July 21, 2017

DSEL File No.: 16-855

Re: 102 Bill Leathem Drive
2nd Engineering Comments – Site Plan

DRAWING TITLE
PHASE 1 SITE PLAN

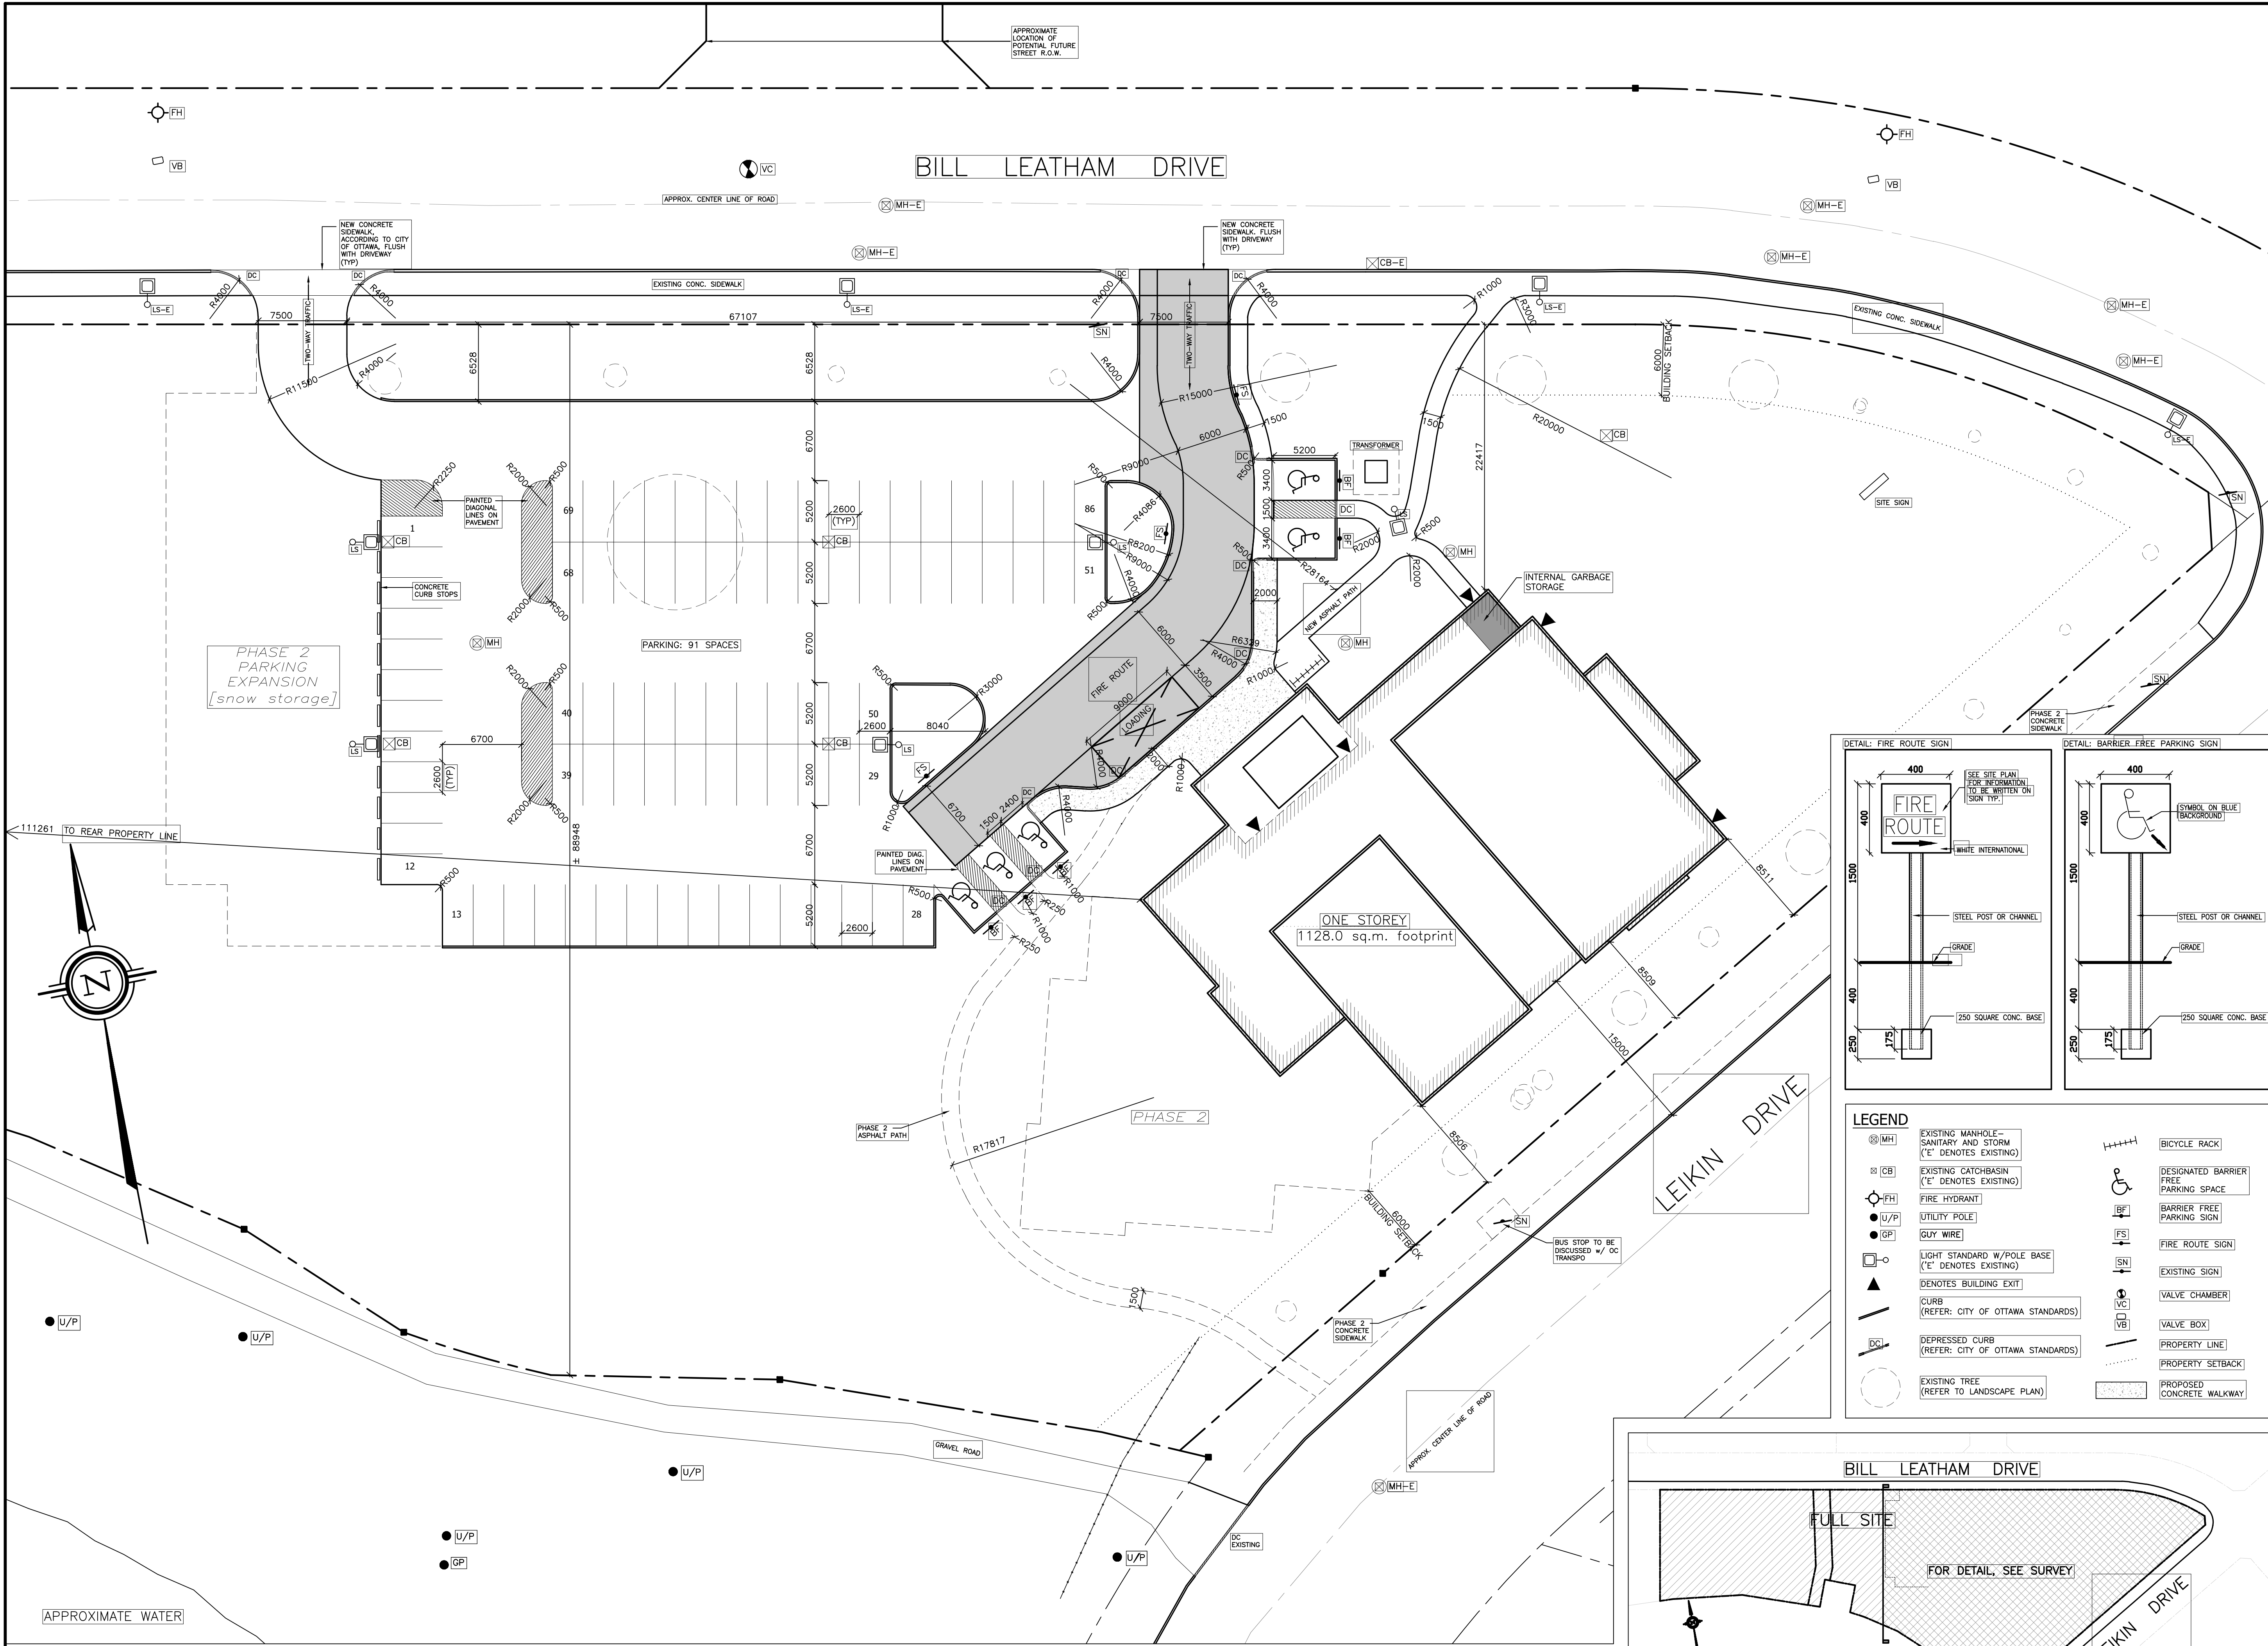
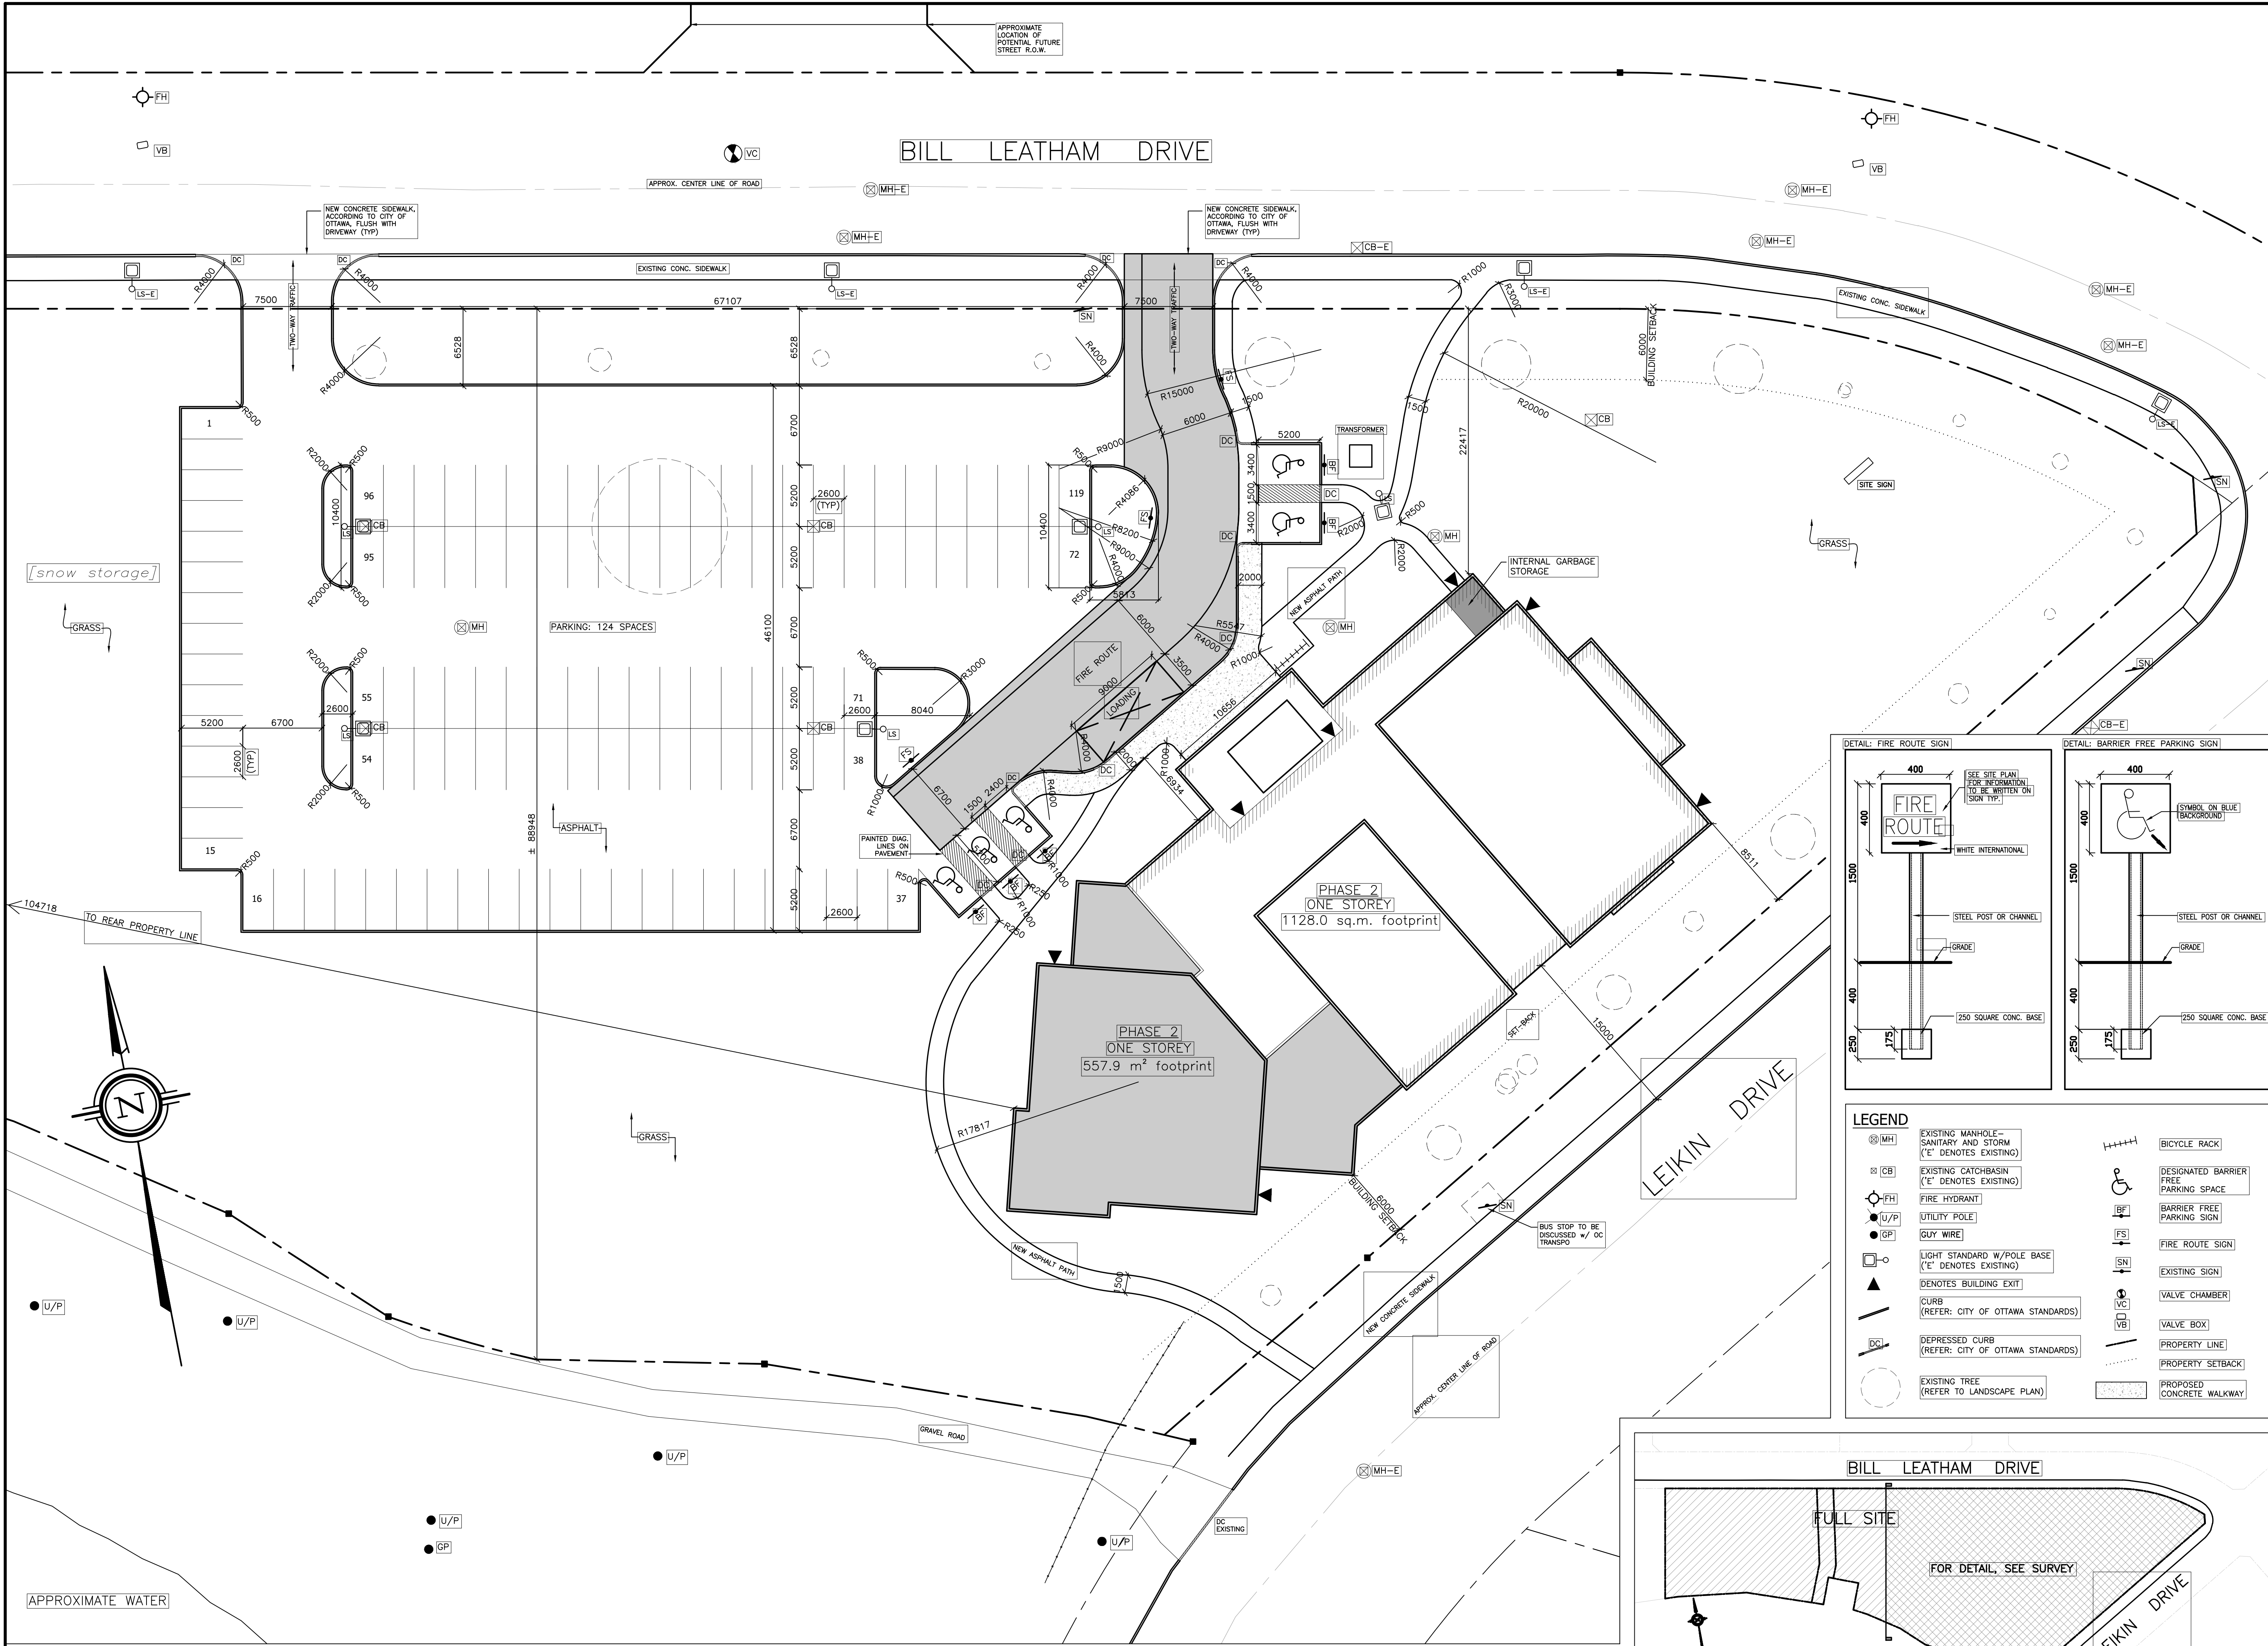
1. All plans must be updated to show the correct detail for the proposed vehicle entrances (private approaches): please show the entrance detail as per the City Standard SC7.1 (unsignalized entrance), and include reference to the City Standard. **Not all plans are correctly updated: please update the Site Plans and Landscape Plans with the correct detail.**
To be addressed by Architect.

2. Resolved.
3. Consider changing walkway material type to concrete for all walkways/sidewalks that connect to the existing sidewalk.
Noted, please refer to Site Plan for walkway material.

4. All plans must show barrier curbs in the parking lot area and at entrances. **Please update to include barrier curb at the western entrance, and extend the temporary curb stop installation in the western portion of the parking lot (northern and southern limits).**
Noted, the drawing has been reviewed and revised to include barrier curbs at the western entrance.
